From: Sarah Burrow <Sarah.Burrow@arun.gov.uk>
Sent: 11 May 2021 12:50
To: Planning.Responses <Planning.Responses@arun.gov.uk>
Cc: Anita Gardner <Anita.Gardner@arun.gov.uk>
Subject: RE: Planning Consultation on: Y/35/21/HH

Engineers Comments Regarding Surface Water Drainage

Application No: Y/35/21/HH
Registered: 22nd March 2021
Site Address: 35 Park Drive Yapton BN18 0JF
Grid Reference: 498159 102876
Description of Works: Proposed single storey rear extension

Typical Geocellular soakaway Unit (for use in soft landscaped areas)

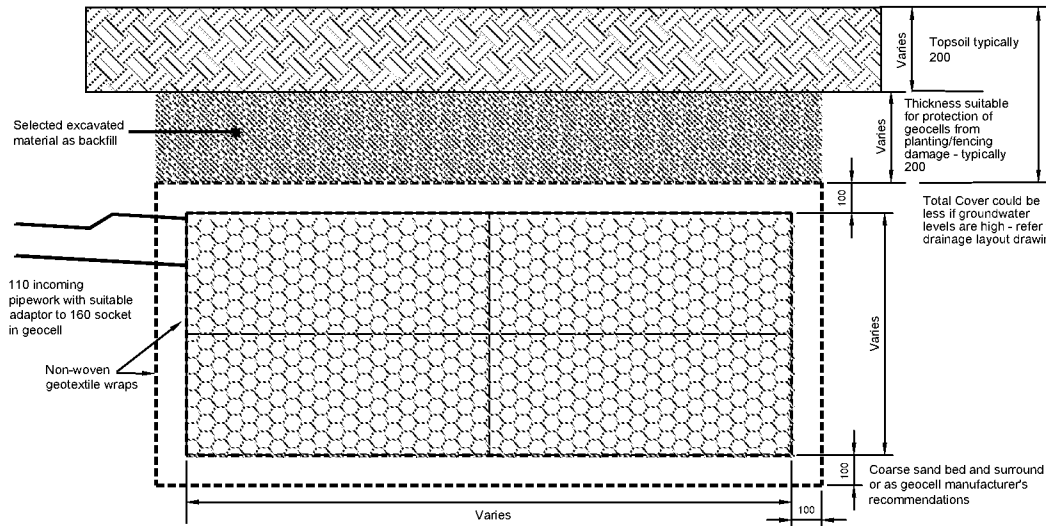
(it is worth noting for future reference that we would expect the base level, cover level and invert level of incoming pipes to be shown on the soakaway construction detail, however this information can all be found on elsewhere in the submission and as such I will not request it and delay determination for an application of this scale.)
